**KIRKLEES METROPOLITAN COUNCIL
INVESTMENT & REGENERATION SERVICE**

DELEGATED DECISION TO DETERMINE PLANNING APPLICATIONS

Reference No: 2021/62/93211/W

Description: Erection of single and two storey rear extension and exterior alterations

2196 – D – 20 – 005

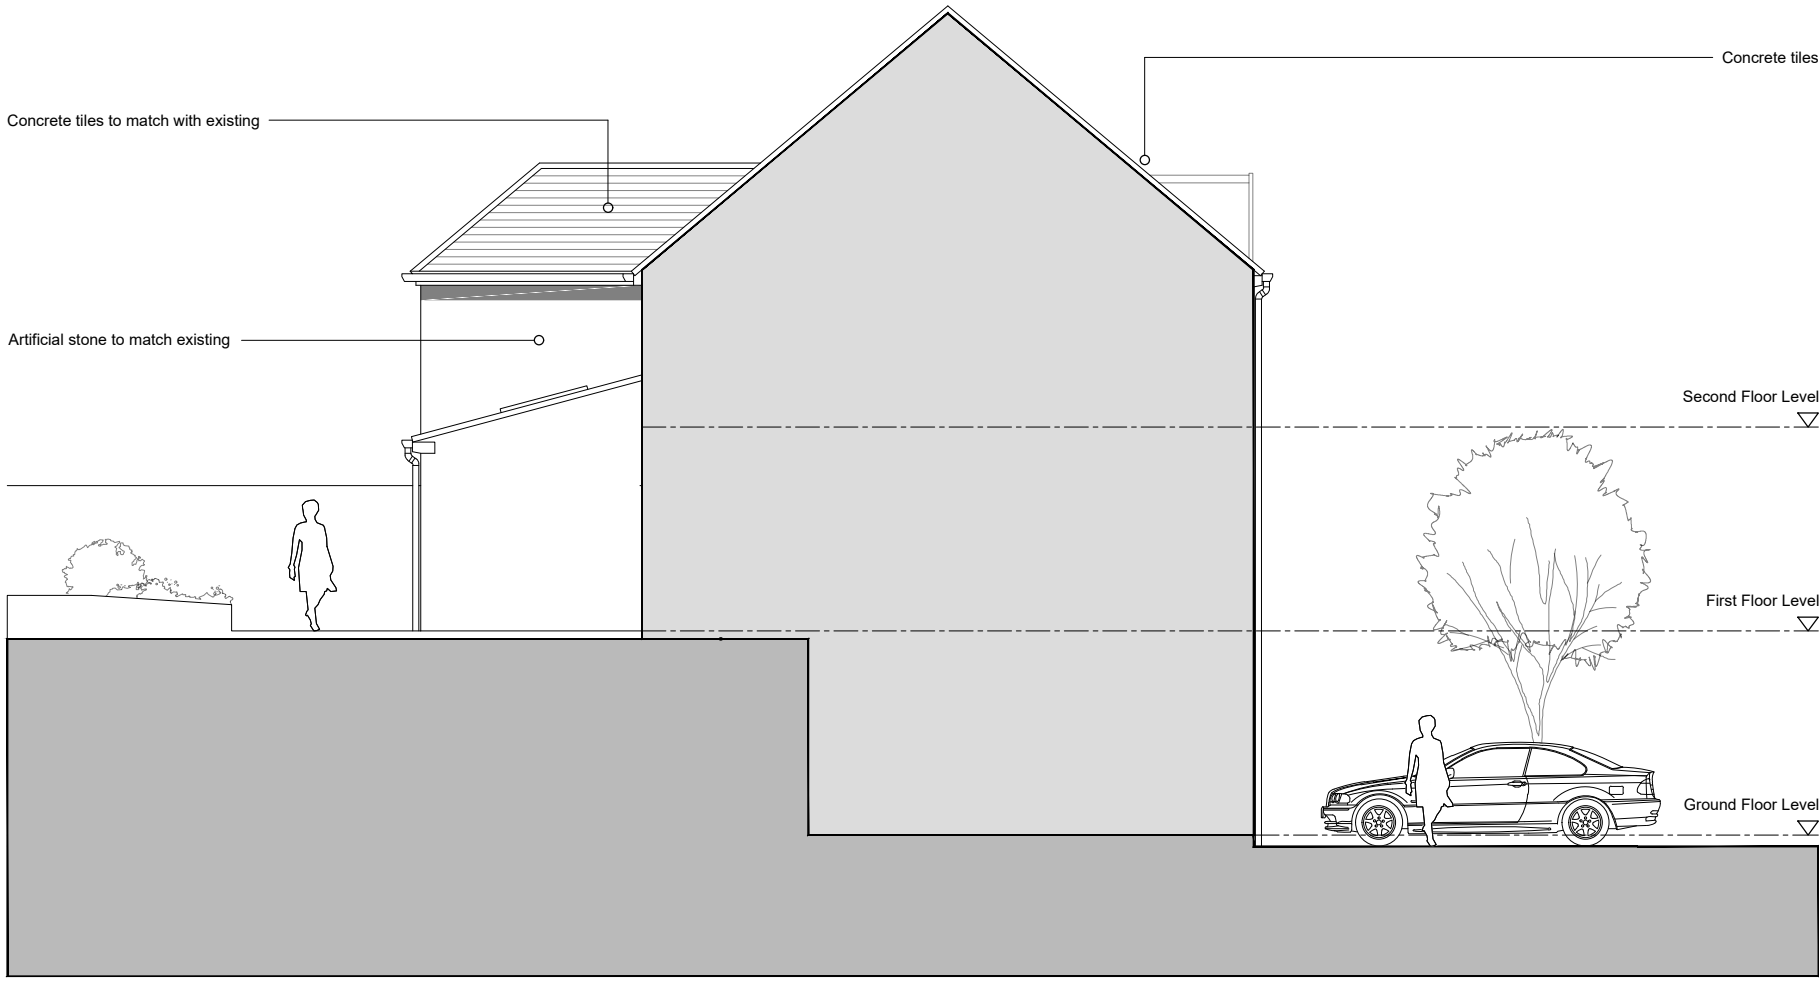
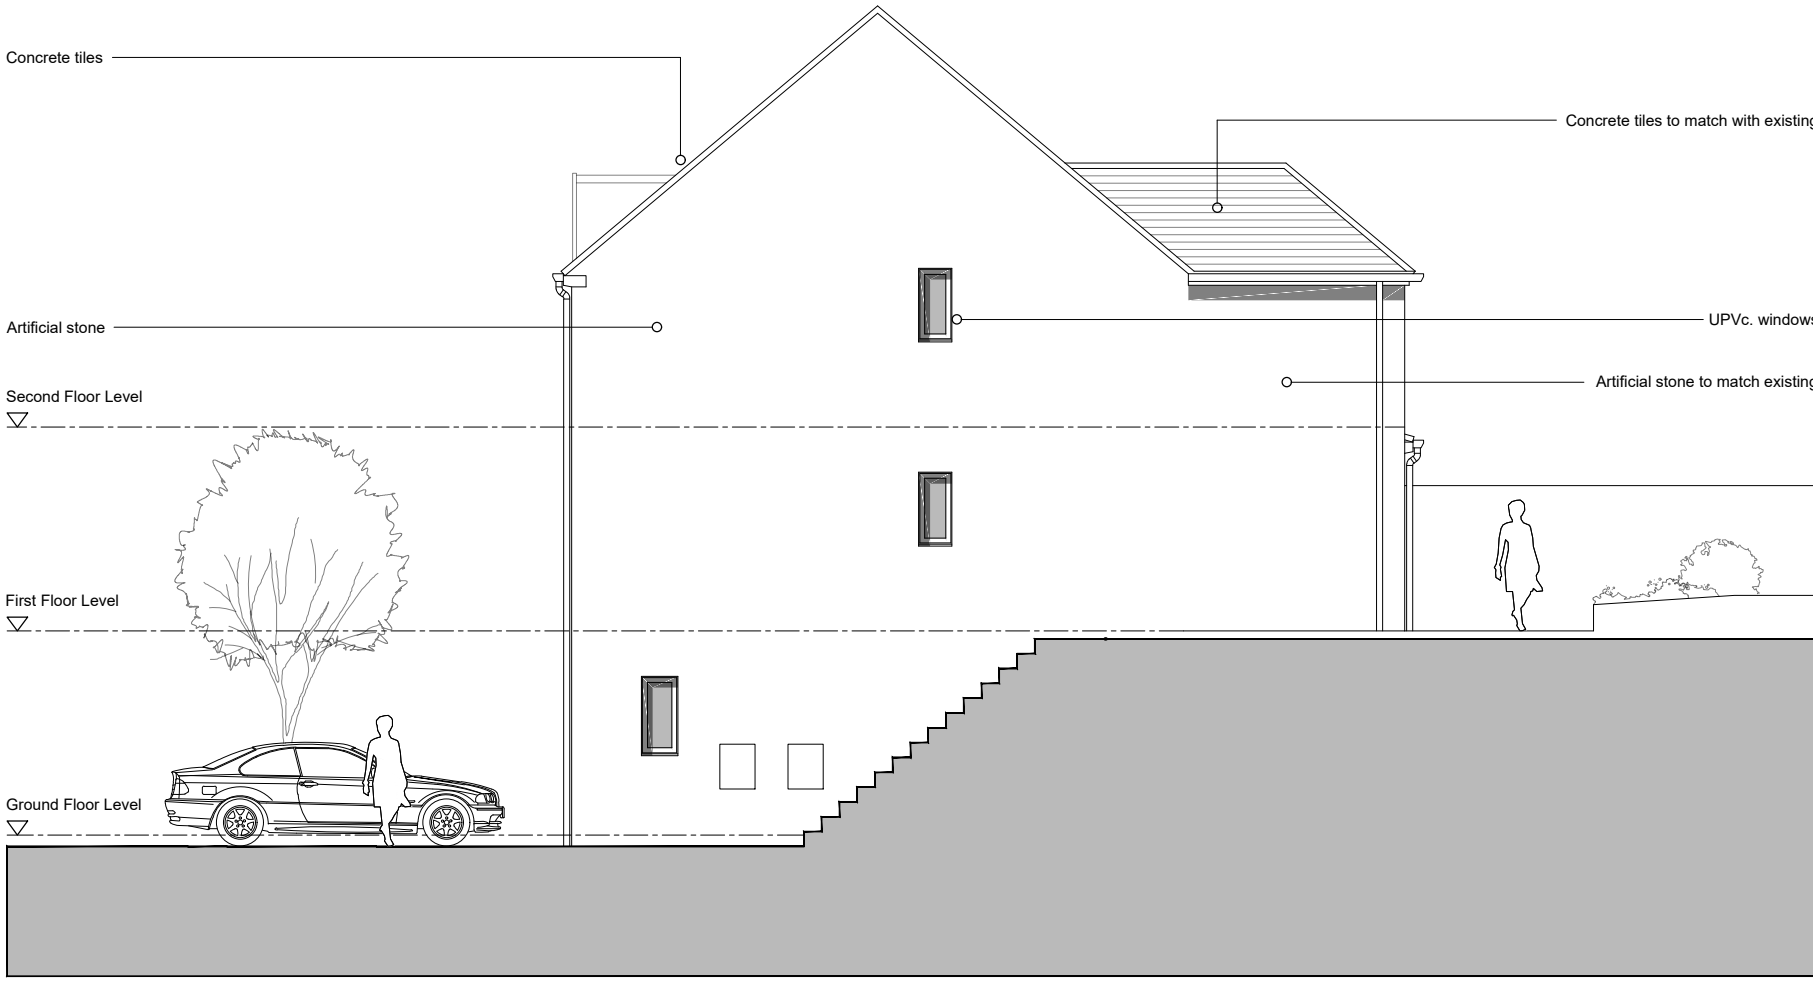
In this case the extension has been designed to reflect the host property with regards to the roof design and would be built from matching materials. The extension is relatively small in scale, remaining subservient to the host building.

The extension would allow access to the rear garden and would not project beyond the gable. Therefore, there would be limited view from the street scene, albeit the 2-storey element would be partially visible through the open vista over the existing garages due to the difference in levels. However, this view is limited and given the design of the proposal, subject to condition the extension is construction from matching materials, is not considered to harm the visual amenities / character of the host property / wider street scene.

The two-storey element would be set approx. 2m from the shared boundary, with a projection again of 3m. The ridge over the extension would be set down from the host property, having a hipped roof reducing its bulk. Therefore, it is concluded the rear extension would have limited overbearing or overshadowing of this neighbour given the size and position of the extension.

With regards overlooking for the neighbours either side there are no windows proposed in the side elevations, therefore, no increased levels of overlooking would occur.

Client	Steph Raynor	Issued From	
Project	2196 : 48 Austin Close : Domestic Extension	Date	June 2021
Title	Proposed First and Second Floor Plans	Scale	1:50 @ A1
Drawn	BH	Auth	BH
Drawing Number	2196 - D - 20 - 004	Revision	-

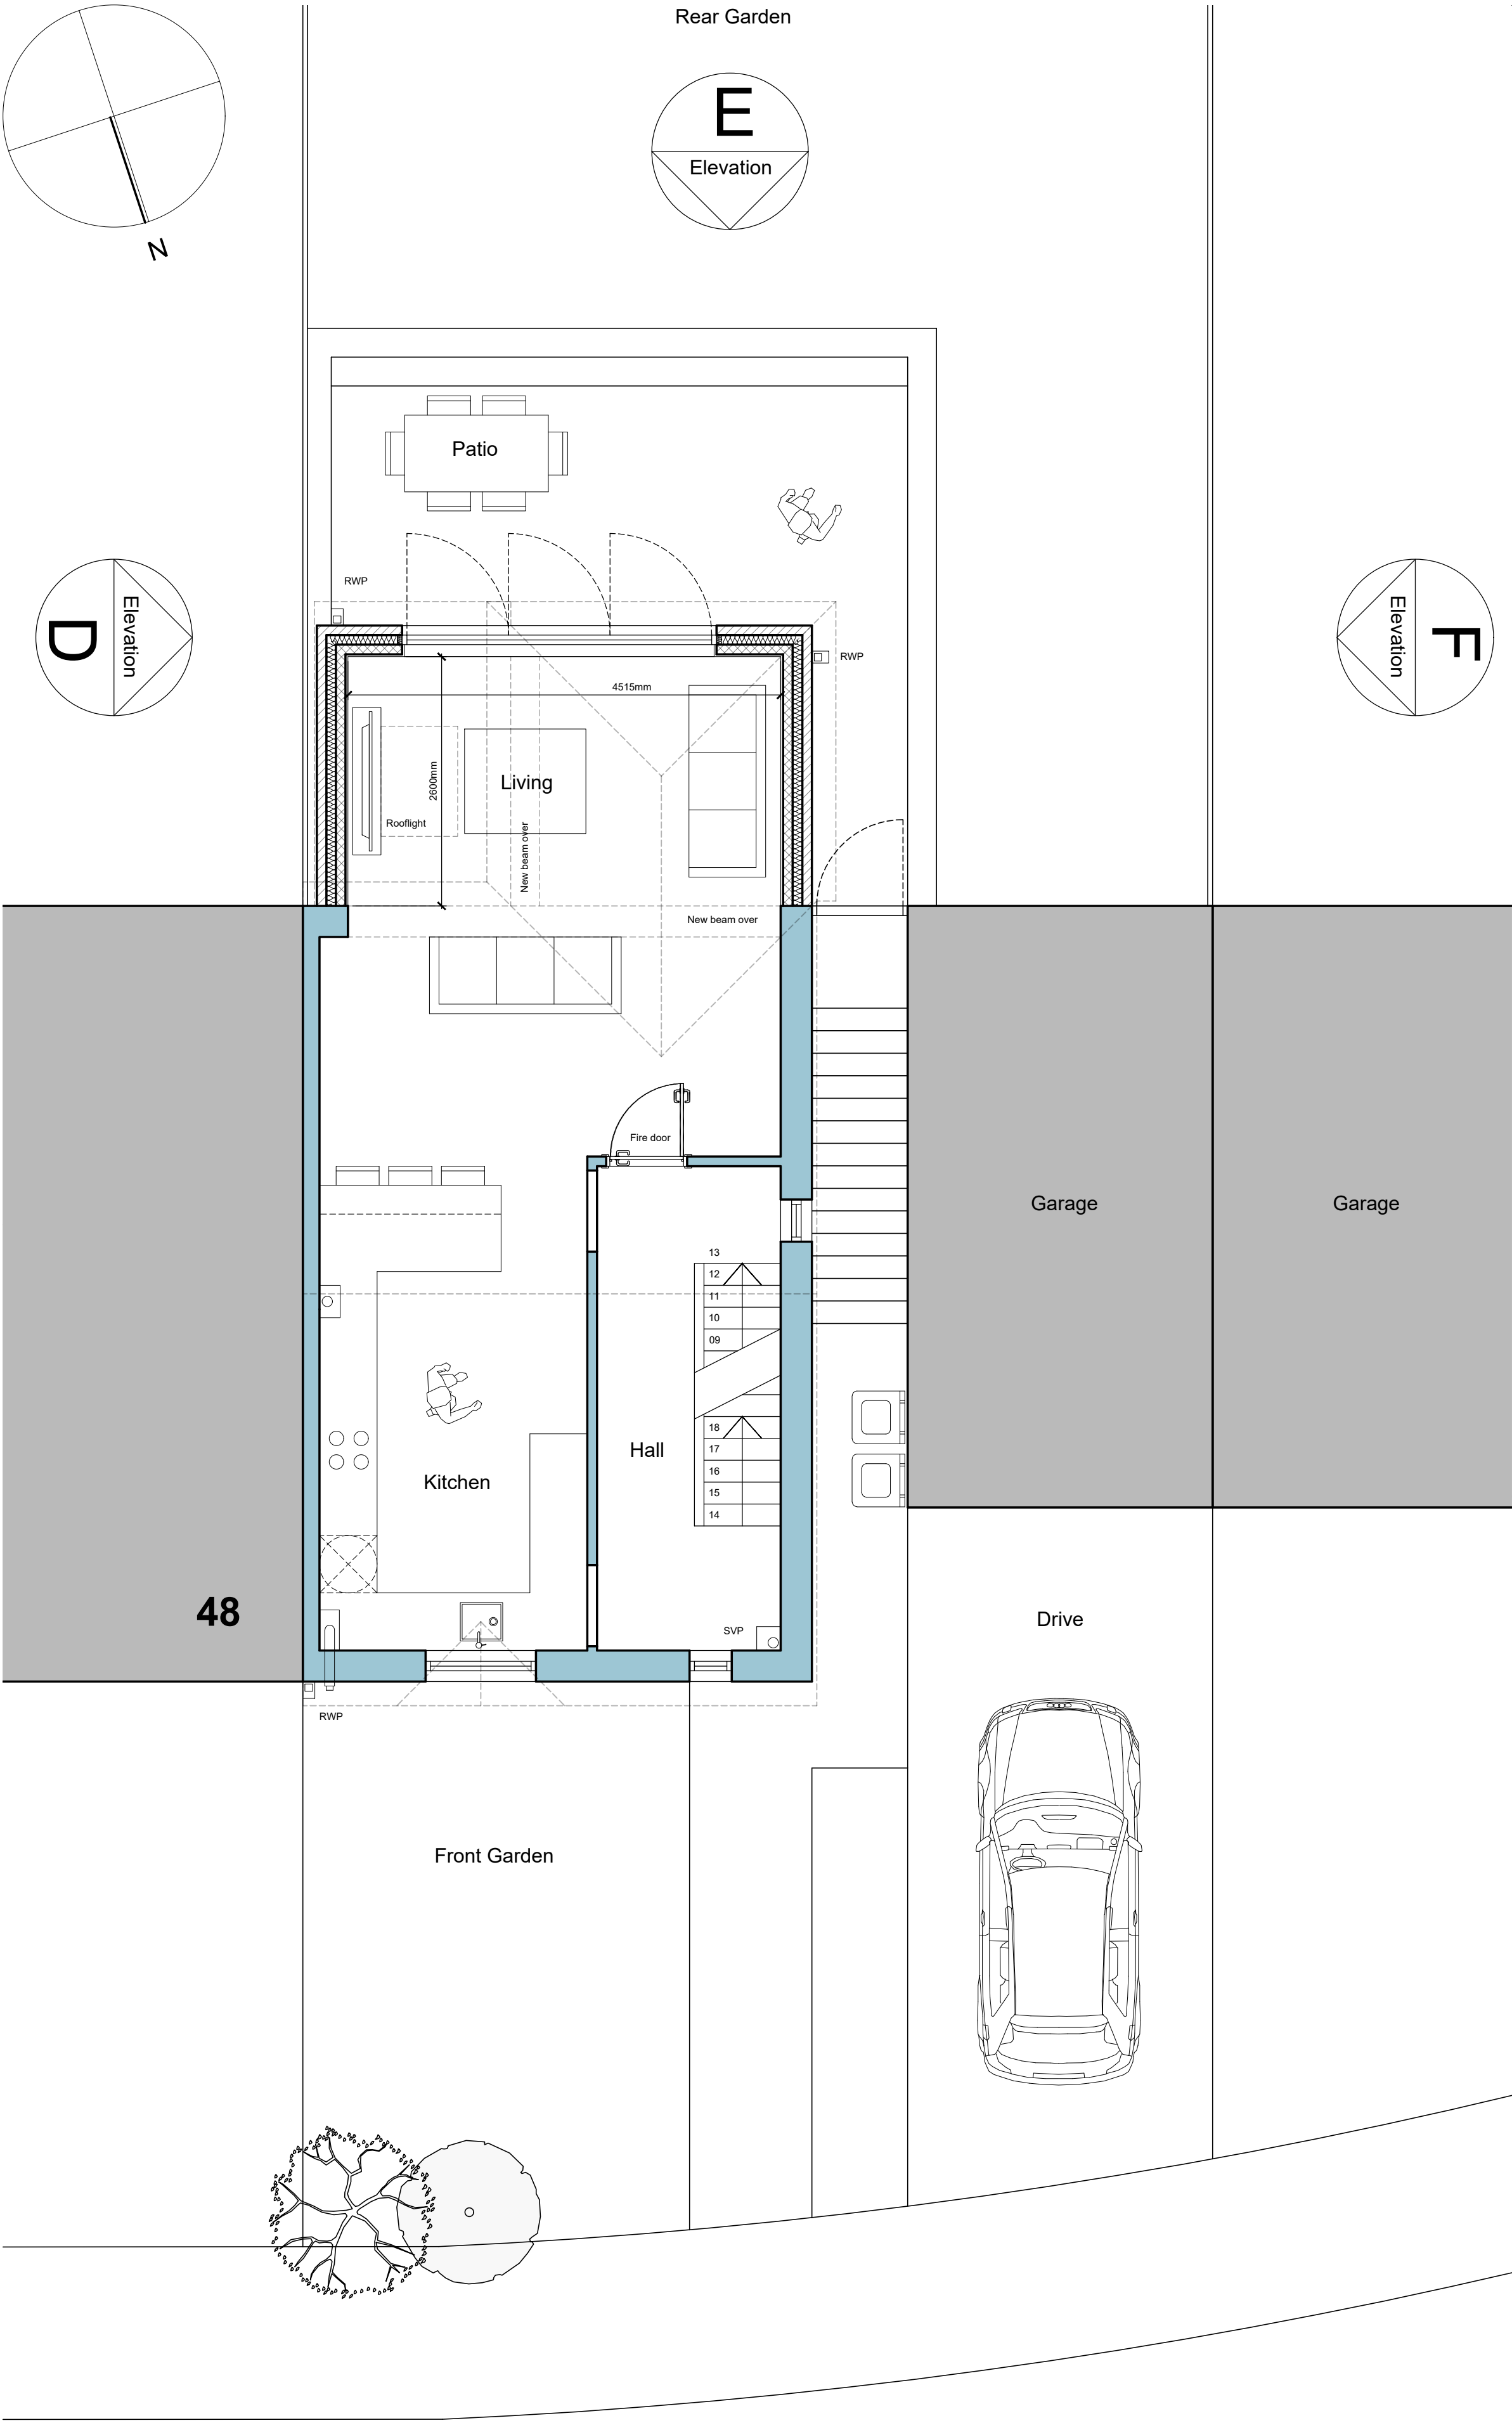
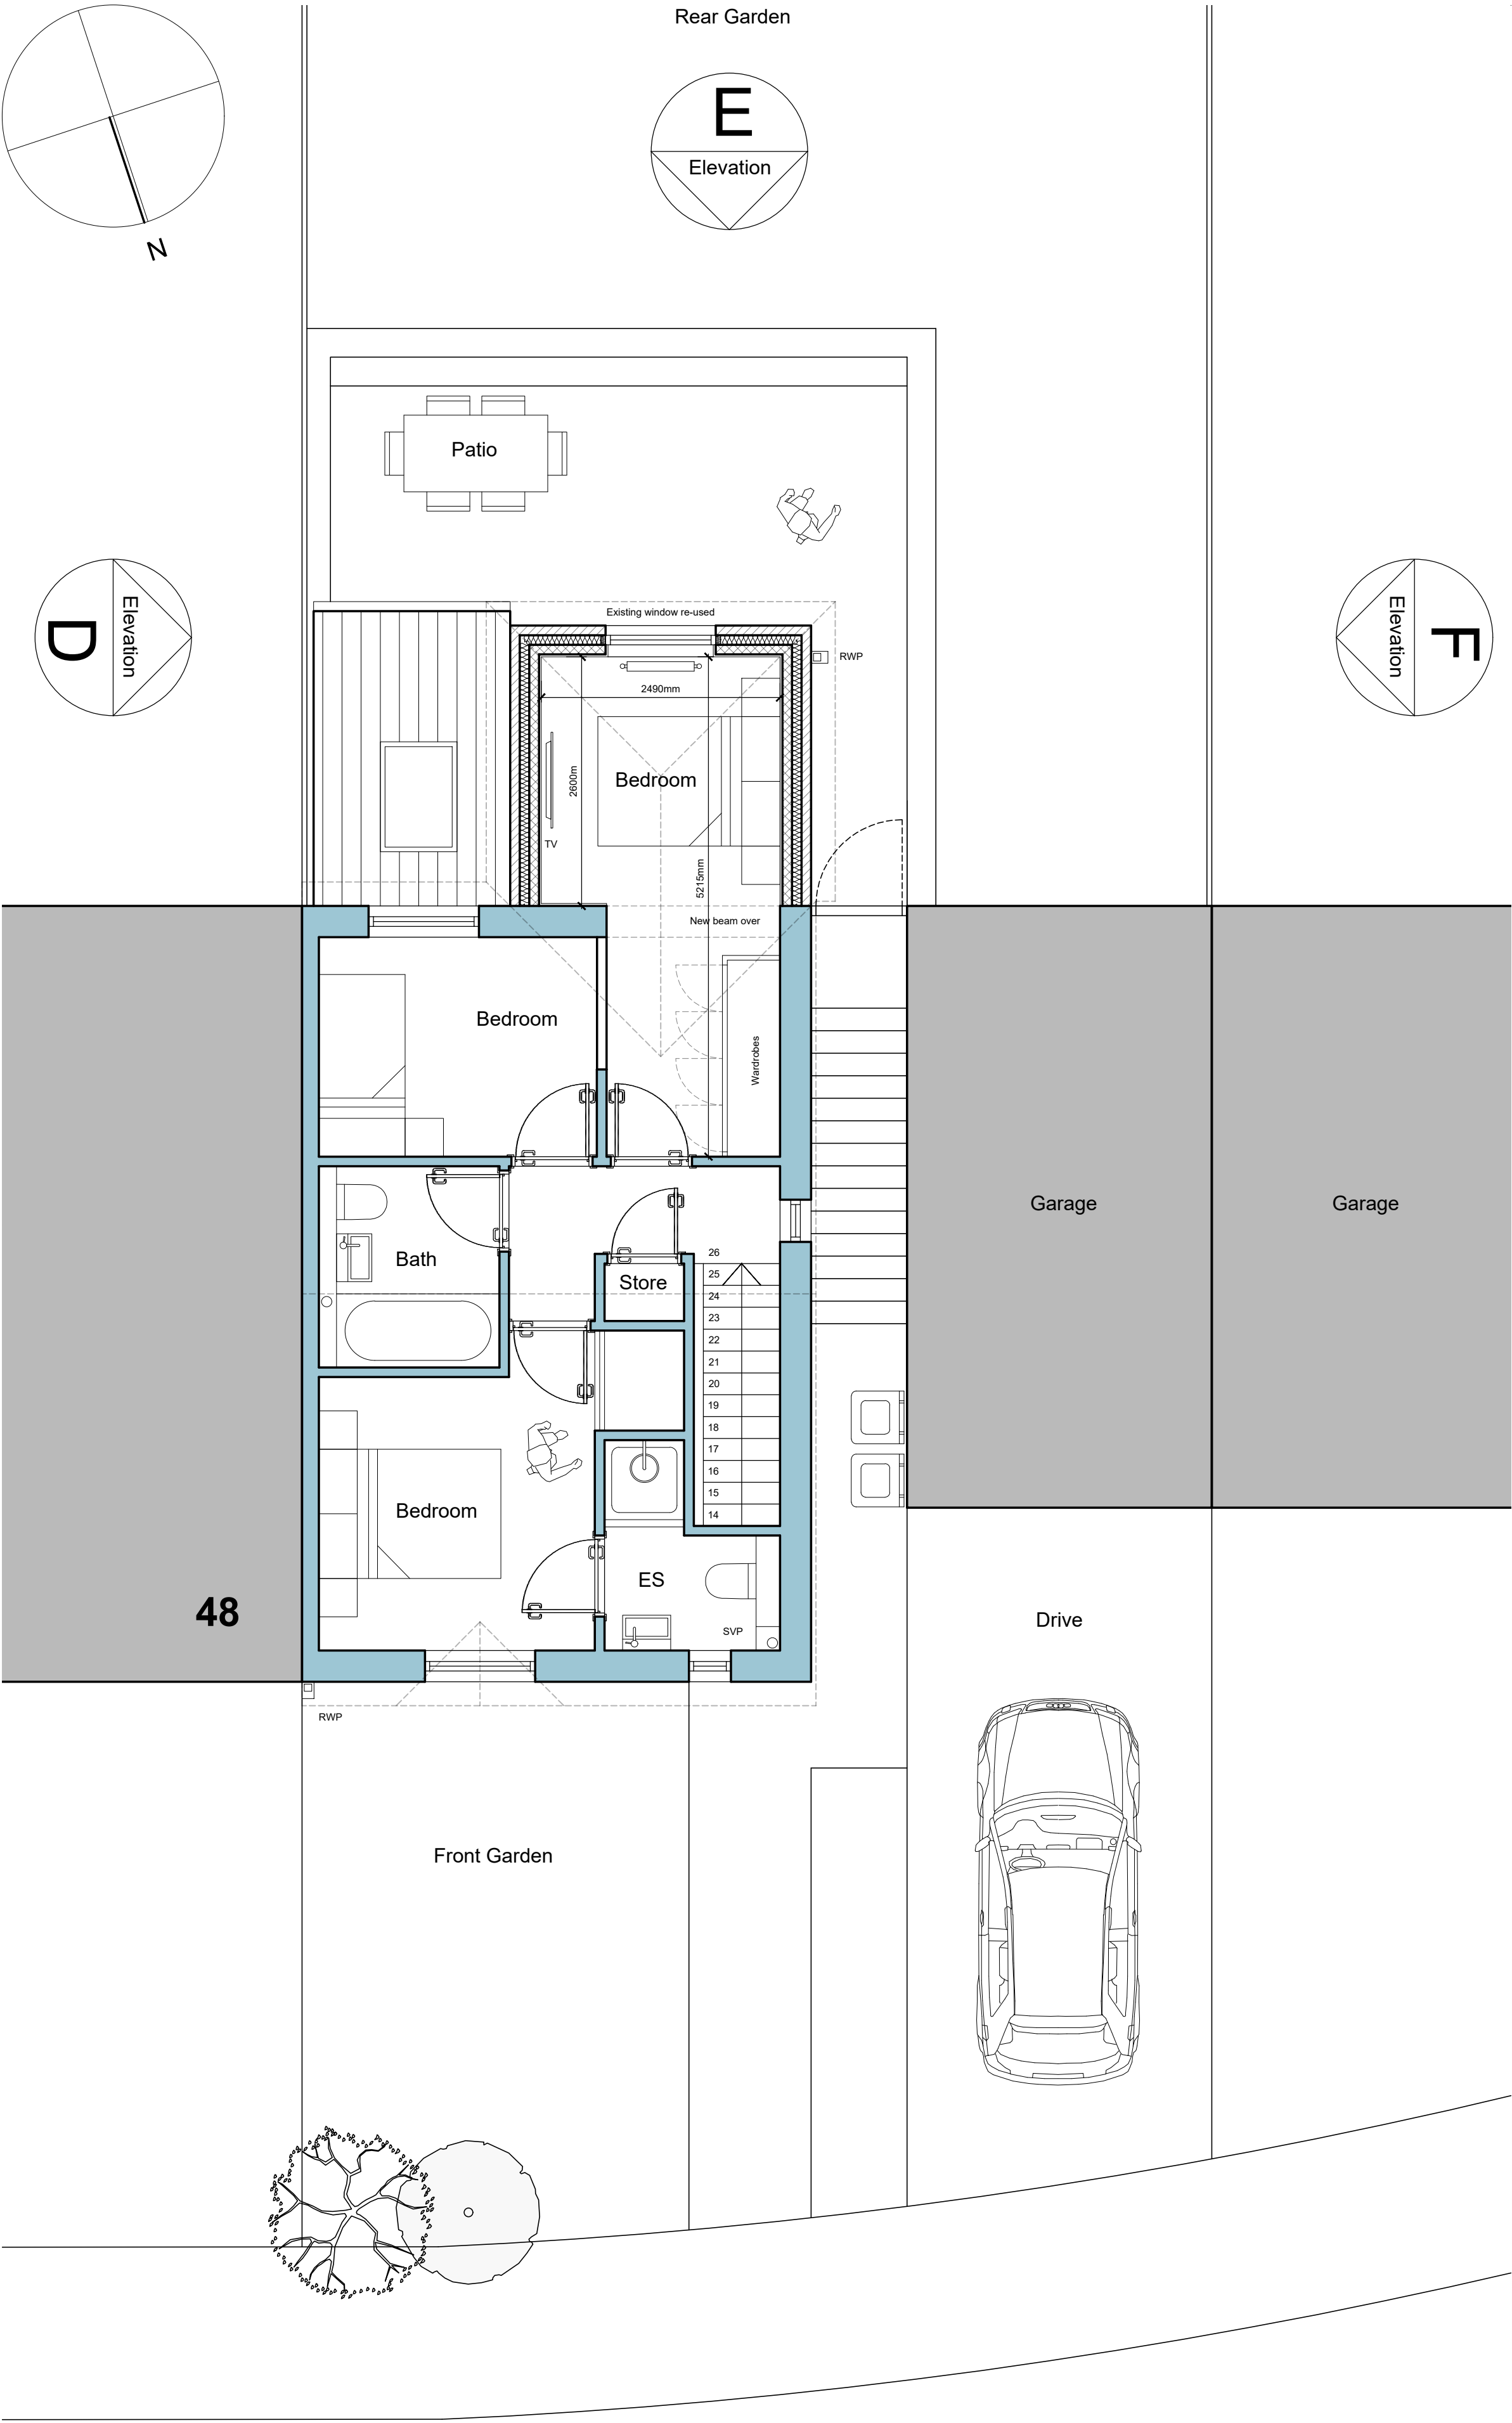
The application is for a part two storey part single storey rear extension the single storey element being the full width of the rear elevation of the property with a first-floor extension partly over. The extension would enlarge the existing living room area and the existing 4th bedroom.

The extension in this case would increase the amount of liveable space in the property and enlarge an existing bedroom, however, given the current arrangements it is not considered necessary to require additional parking to be provided given the number of bedrooms would remain unaltered .
